## **Development Facilitation Team (DFT) – Review Comments**

**DRB Project No: PR-2019-002668 Date: 04/26/2023 Agenda Item: #2 Zone Atlas Page: D-17**

**Location: 4000 Ellison St. NE (Ellison and Washington)**

### **Application For: SD-2023-00087 - Vacation of Public Easement (Water) (DHO)**

PLAT FOR
LOT 28-A-1
INTERSTATE INDUSTRIAL TRACT
 (A REPLAT OF LOT 28-A, INTERSTATE INDUSTRIAL TRACT)
 WITHIN THE
 ELENA GALLEGOS GRANT
 PROJECTED SECTION 23,
 TOWNSHIP 11 NORTH, RANGE 3 EAST, N.M.P.M.
 CITY OF ALBUQUERQUE
 BERNALILLO COUNTY, NEW MEXICO
 FEBRUARY, 2023

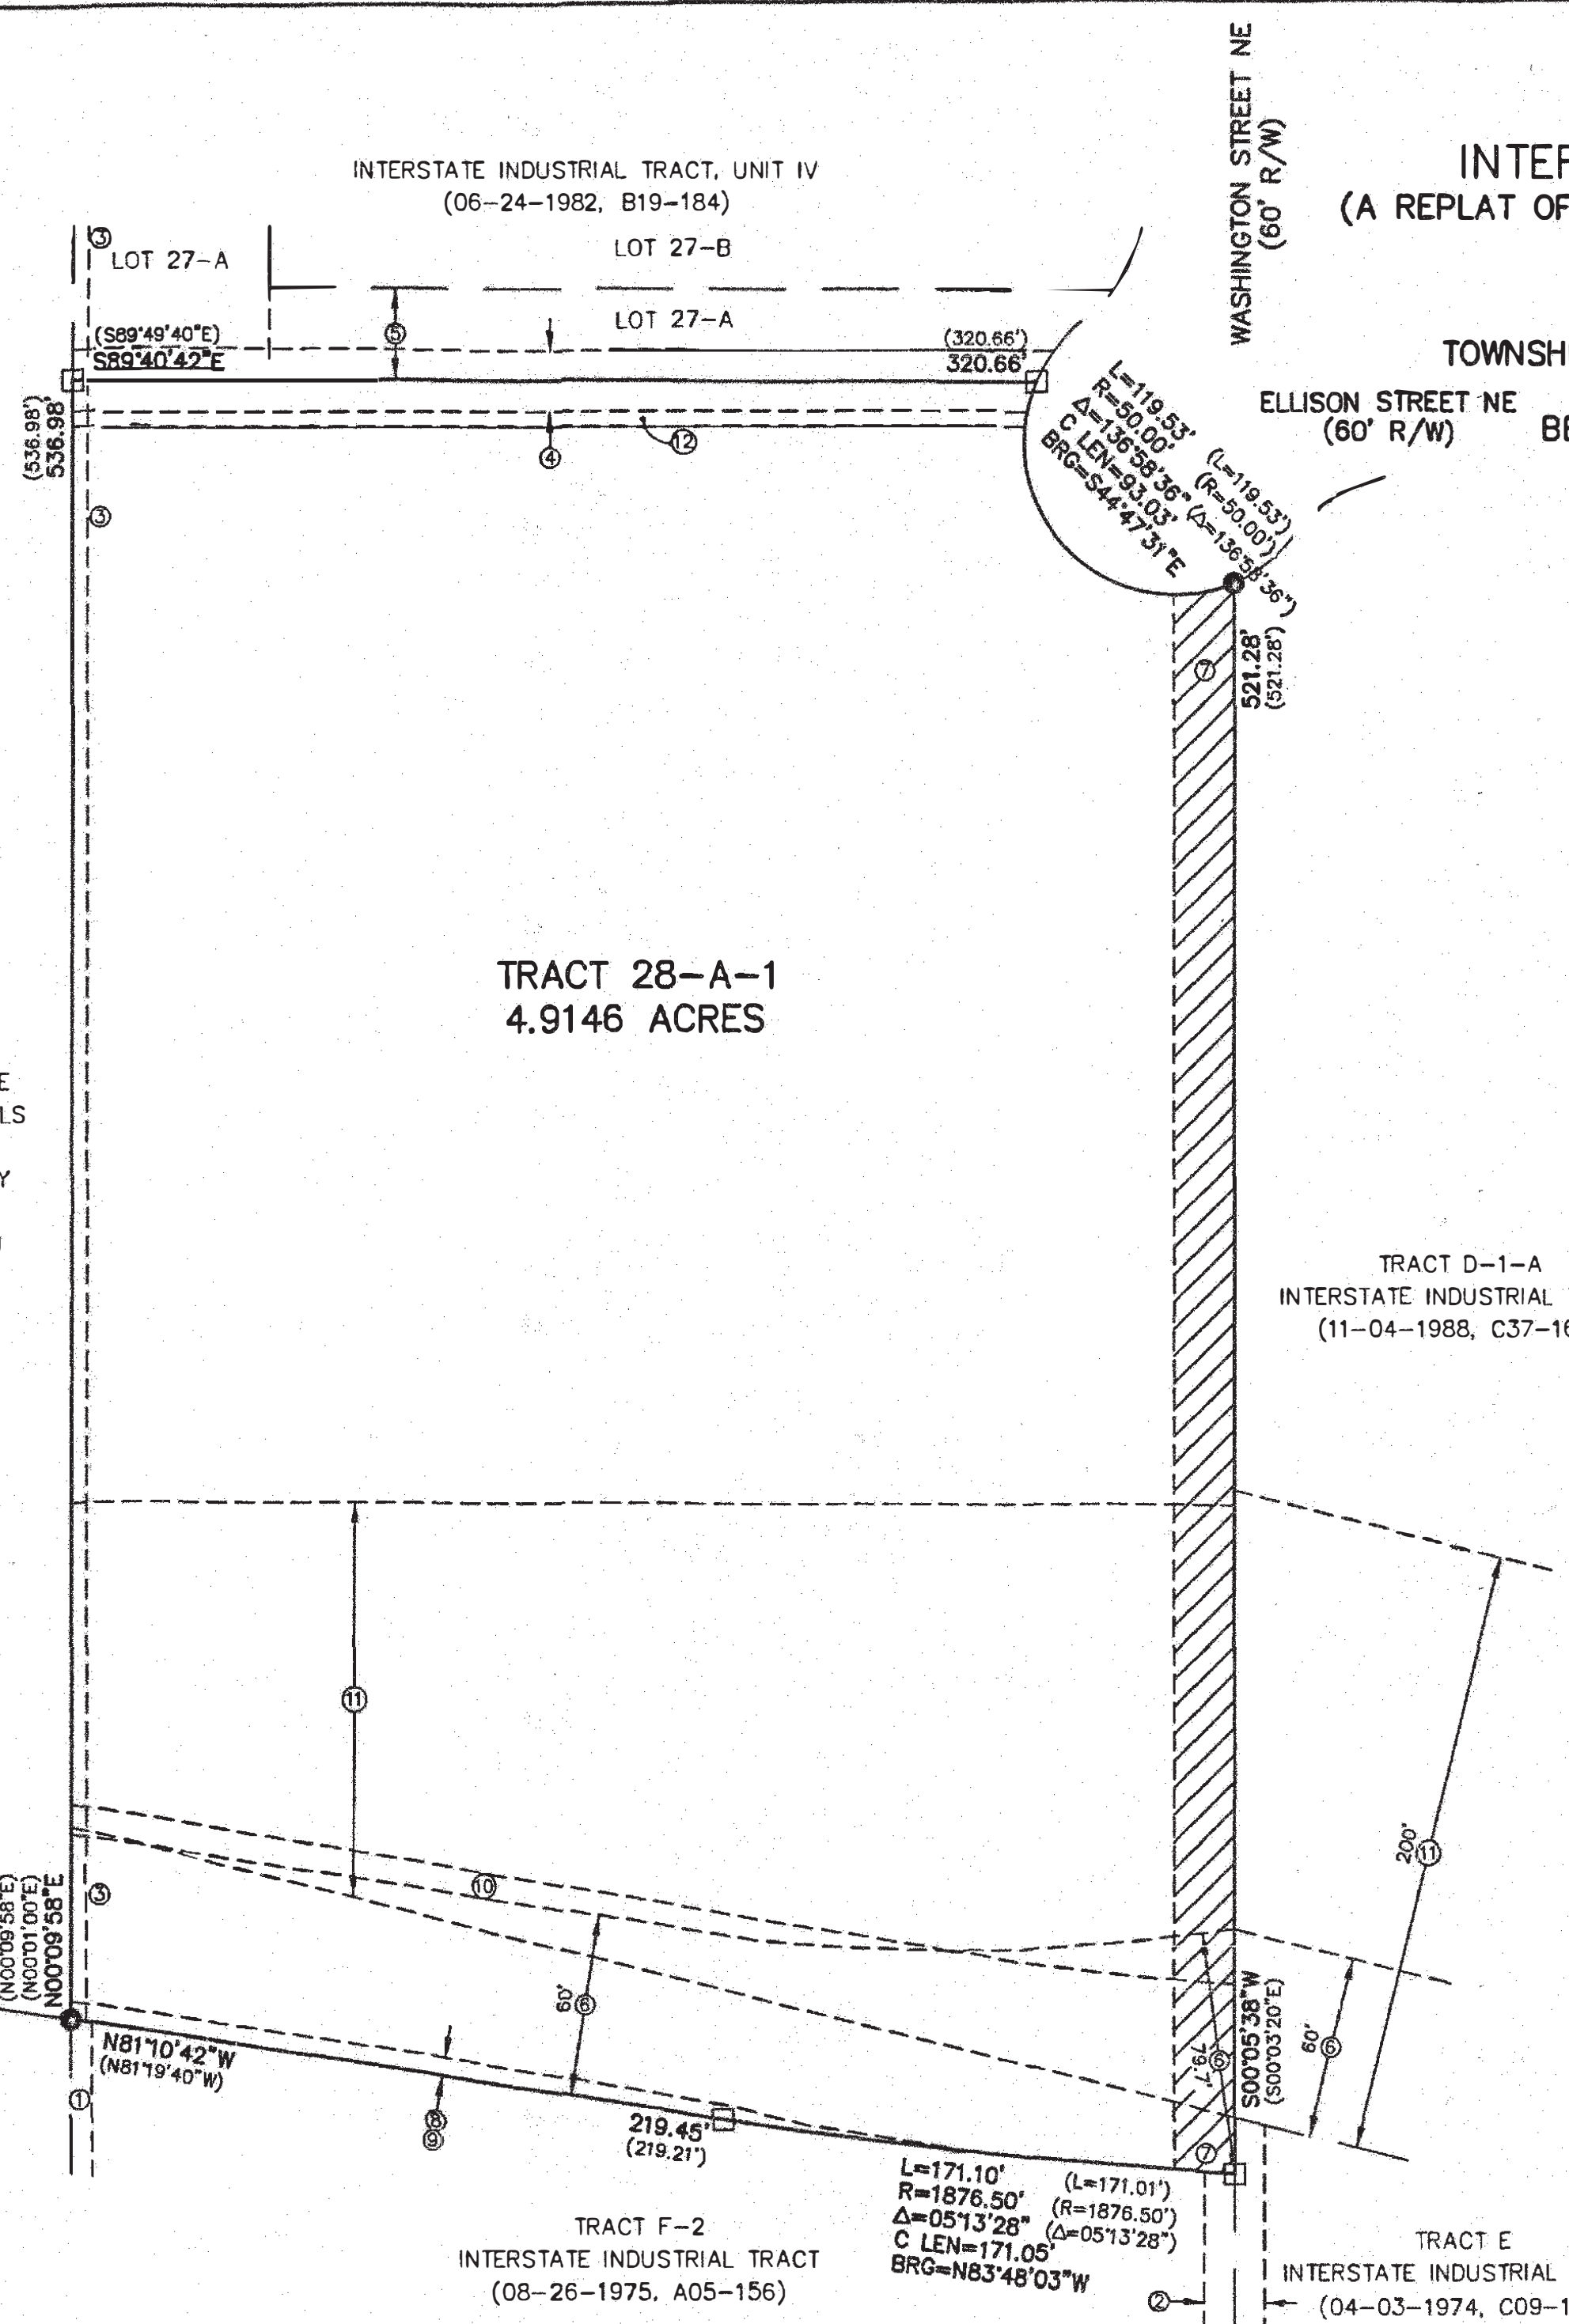
1. No objection to the proposed waterline easement.
  - a. This has been discussed and the existing infrastructure will be decommissioned by the Water Authority via the active connection permit.
  - b. The line was found to have inaccurate as-built information therefore is no longer a viable line and can be removed from the public infrastructure operated by the Water Authority.

- The Applicant must address the South Pino Arroyo Wing Dike in the Plat.
- The entrance of the lot is the intersection of Ellison St and Washington St. Ellison Street is a Minor Collector and the sidewalk is supposed to be 6ft with a 5-6 buffer landscape. Washington St is a local Street with a 5ft sidewalk and a 4-5 or 4-6 Buffer landscape. Both of these streets are Bike Routes.
- The project and application numbers must be added to Plan sheets, prior to the final sign-off from Planning.
- DXF File approval from AGIS will be required for the Final Plat, and must be obtained and included with the Final Plat application submittal prior to the final sign-off of the Plat should the Plat be approved by the DRB or the DHO.

- The applicant proposes to vacate an existing 20-foot public utility easement as well as an existing 20-foot ABCWUA water and sanitary sewer easement recorded on October 28, 1982.
- There is one application for two Vacations of Public Easement requests. Both are located in one space.
- Planning staff defer to ABCWUA staff regarding the justification of the vacation of the public easements.
